From: Jean Fraser
To: Ducas, Patrick
Date: 10/9/2015 4:43 PM
Subject: Preliminary comments on draft Plat Re: 415 Cumberland Ave
Attachments: Civil Plan With Recording Platt_1.pdf

I have now had an opportunity to do a preliminary review of the plat a attached, and I have the following comments:

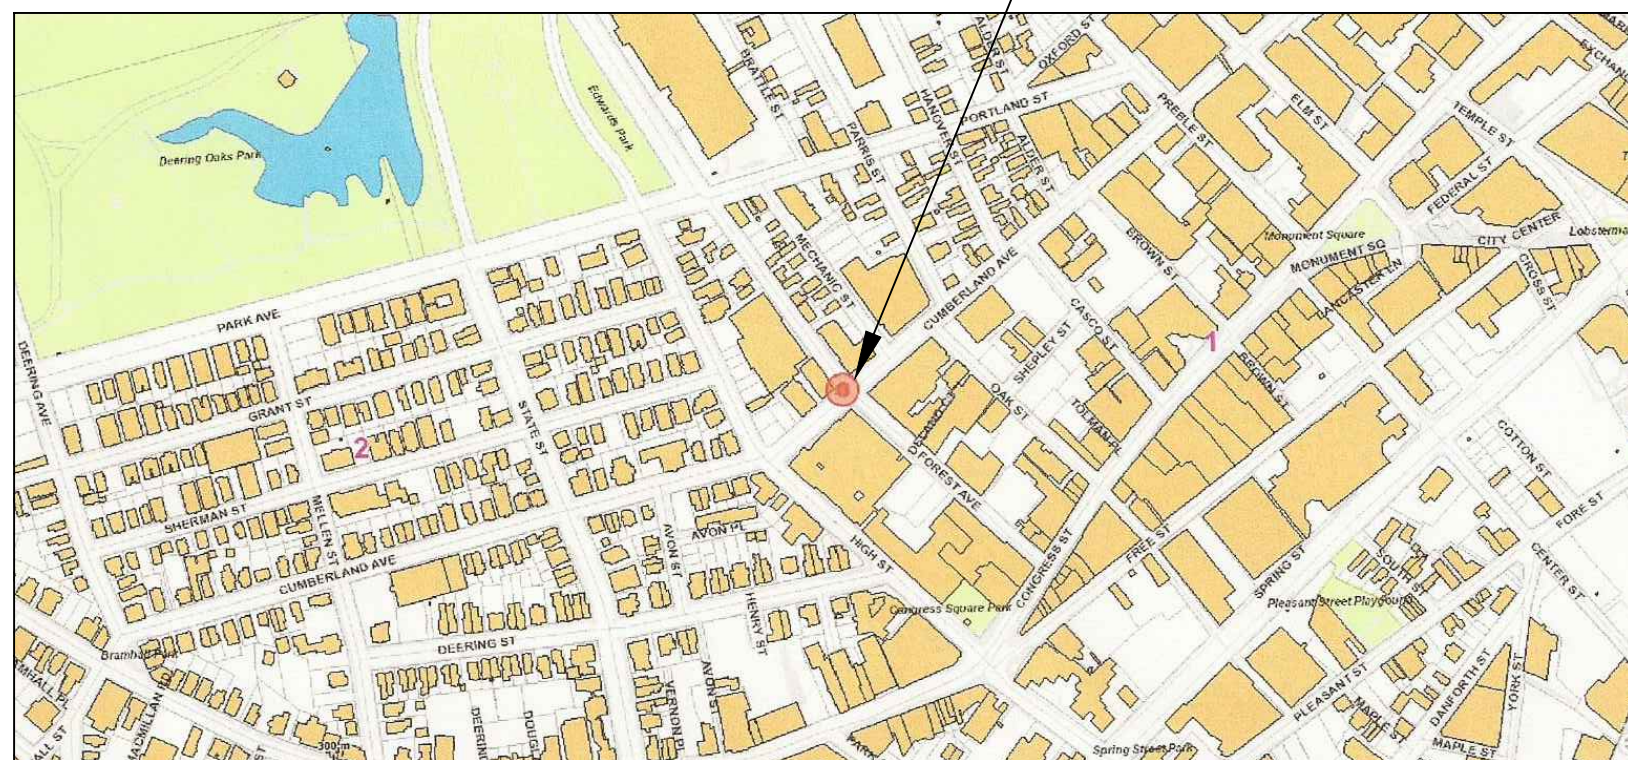
the footprint of the existing building (in sq feet) should be noted under the area of the parcel
the easement is identified as Book 1212 Page 215 in one place and Book 1212 page 217 at another place

Easement should say that it benefits YMCA for xxxx (what it is for)

Does the property have rights over the Burnham lot for the HVAC and fire escape

Who is using area underneath fire escape and if it will be users of your property then an easement may be needed?

A note (prominent) needs to be added stating that the subdivision is for 10 residential units on the X floors and a schedule of the units and sizes and locations should be included

A note needs to be added saying whats happening re the first floor re use

On the plan or in a note the number & location of parking spaces should be stated.
